From: Chantelle Bashford [REDACTED]
Sent: 16 February 2022 16:39
To: Planning.Responses <Planning.Responses@arun.gov.uk>
Subject: RE: Planning Consultation on: BR/294/21/PL

Please see Private Sector Housing comments below. These comments are in relation to general housing conditions and have regard to the Housing Act 2004, Housing Health and Safety Rating System (England) Regulations 2005 and LACORS national fire safety guidance.

Application No: BR/294/21/PL

Site Address: 2-10 The Hatters Inn Queensway Bognor Regis PO21 1QT

Drawing Title:
PROPOSED BASEMENT, GROUND, 1ST FLOORS

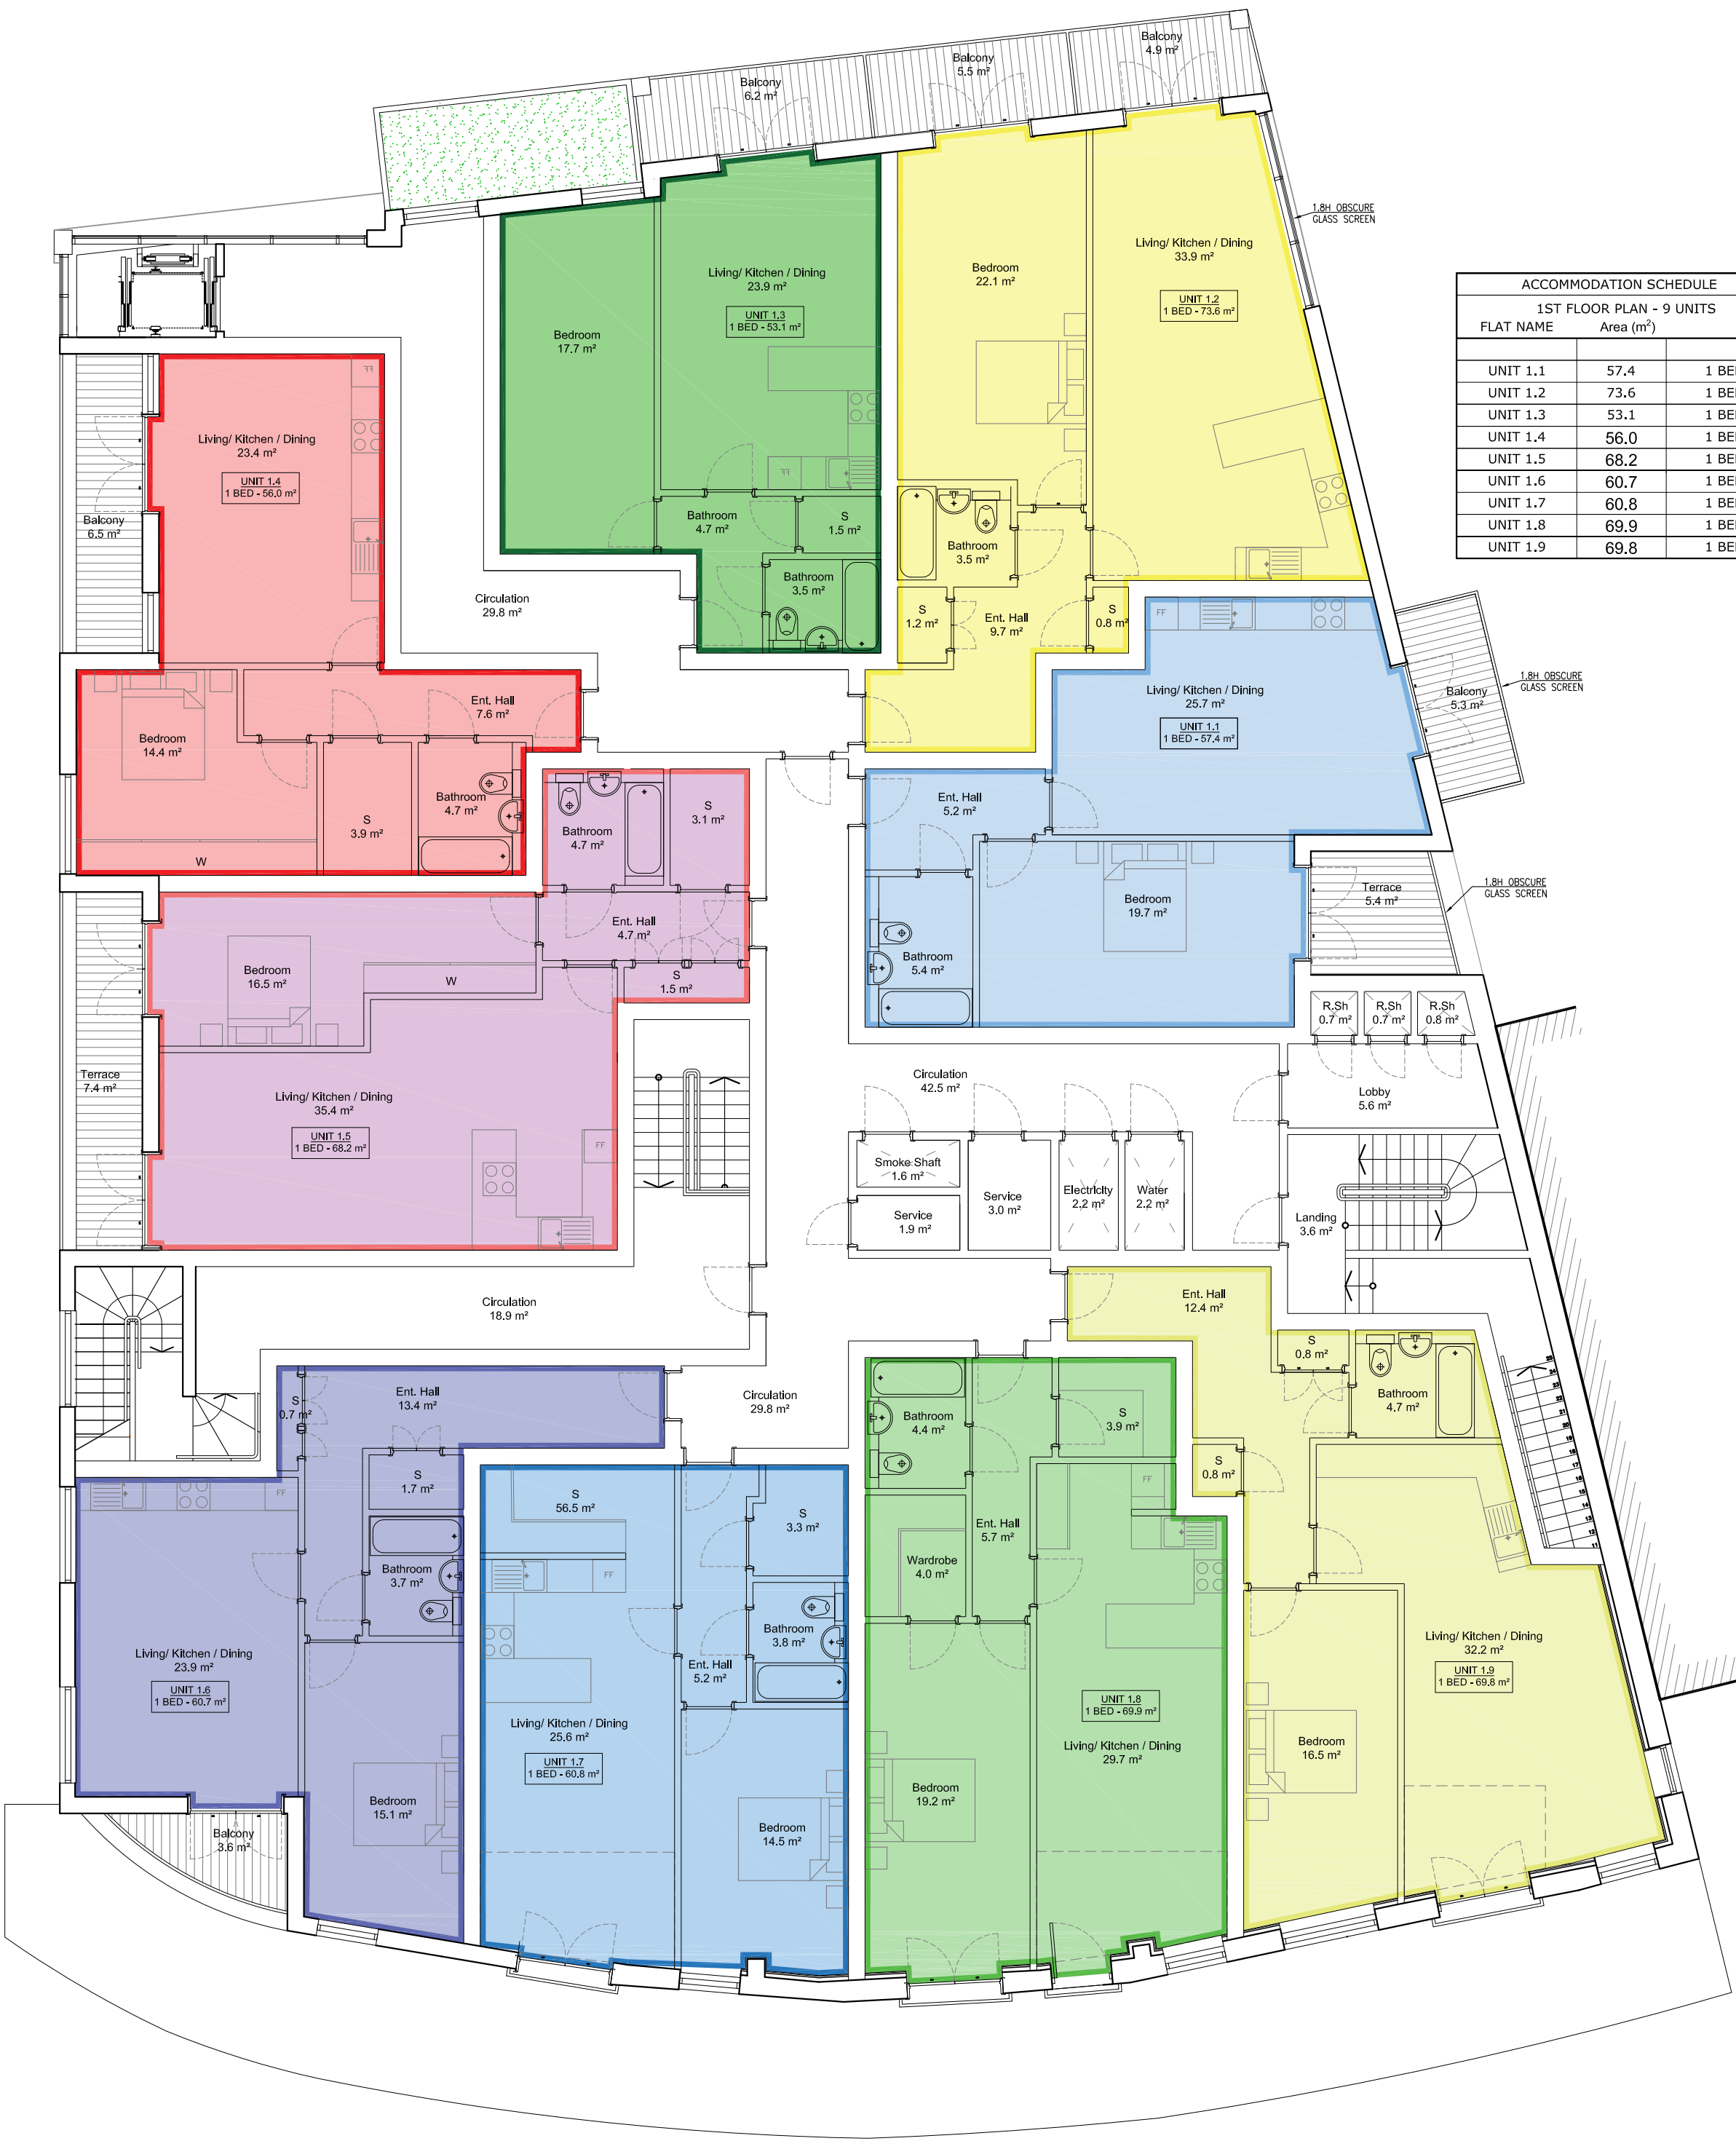
- Throughout the escape routes (first floor to fifth floor) – smoke

- Basement / Bike Store – smoke
- Commercial premises on the ground floor – smoke (and heat if there are cooking facilities)
- All cupboards along the escape route that contain a source of ignition - smoke
- Within each flat in the room/lobby opening onto the escape route – heat

Drawing Title:
PROPOSED 4TH, 5TH FLOOR PLANS

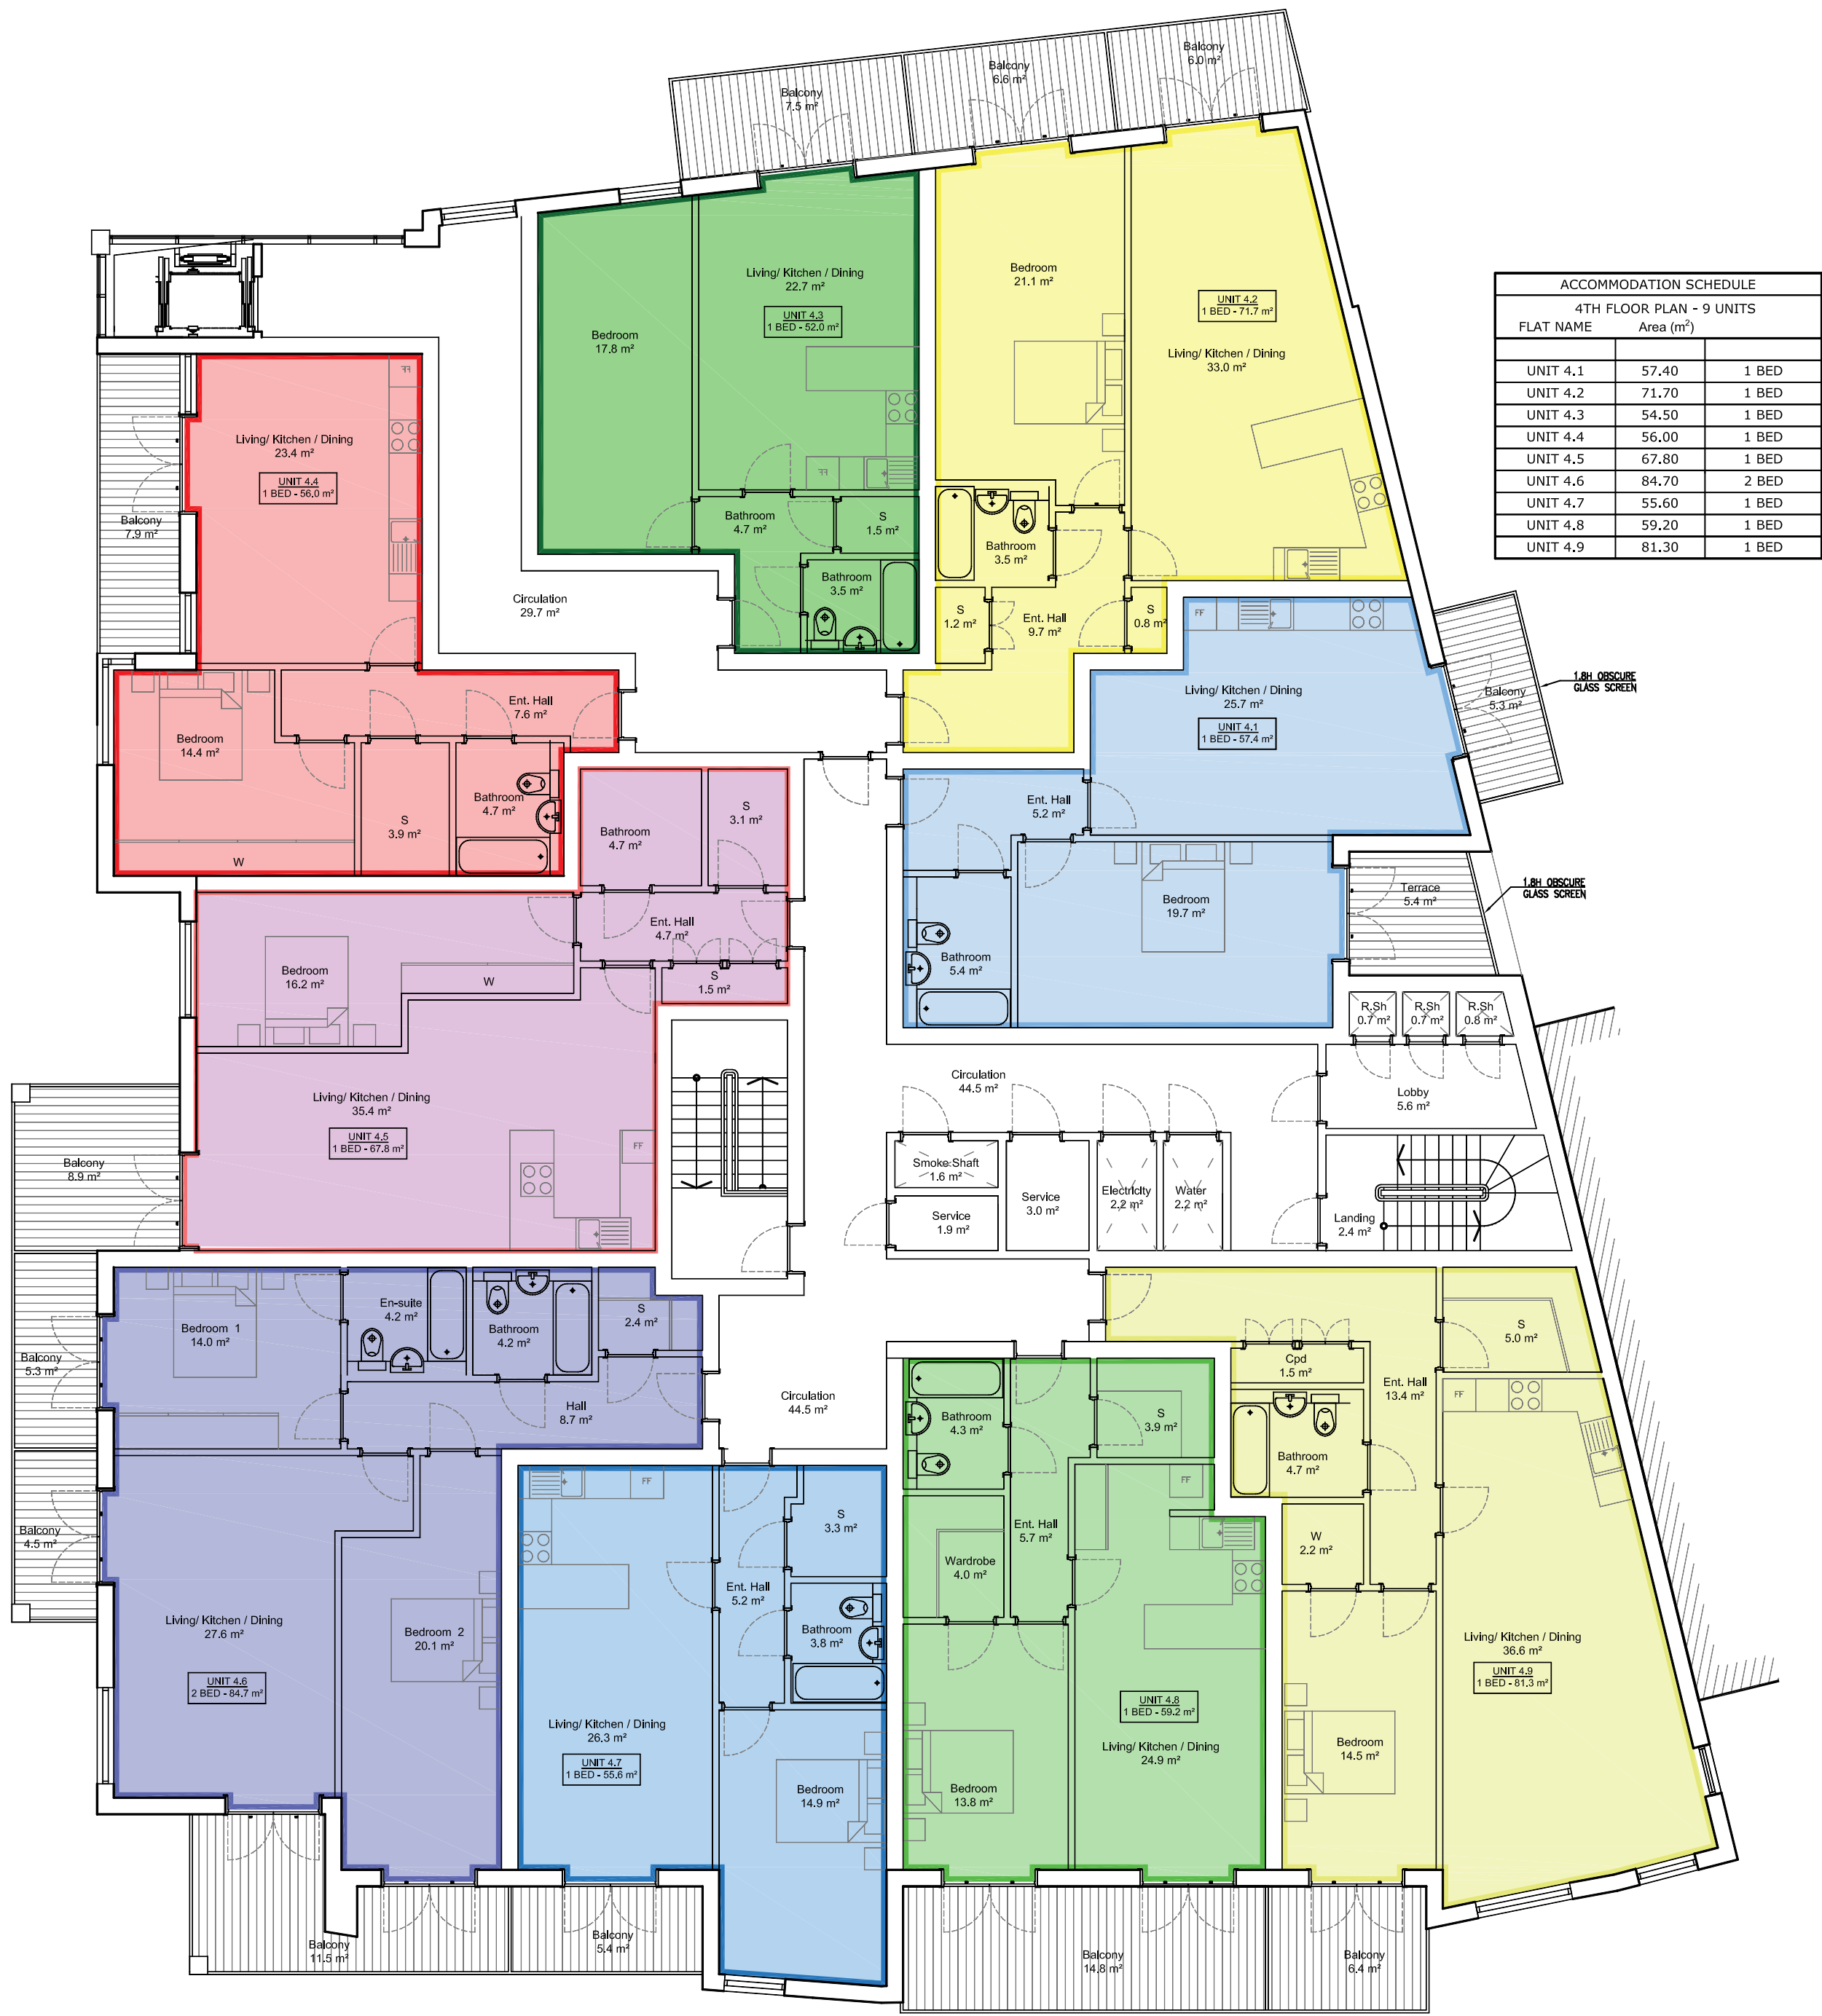
- Each terrace/balcony must provide a guarding height of 1100mm minimum, extending up from the terrace/balcony floor
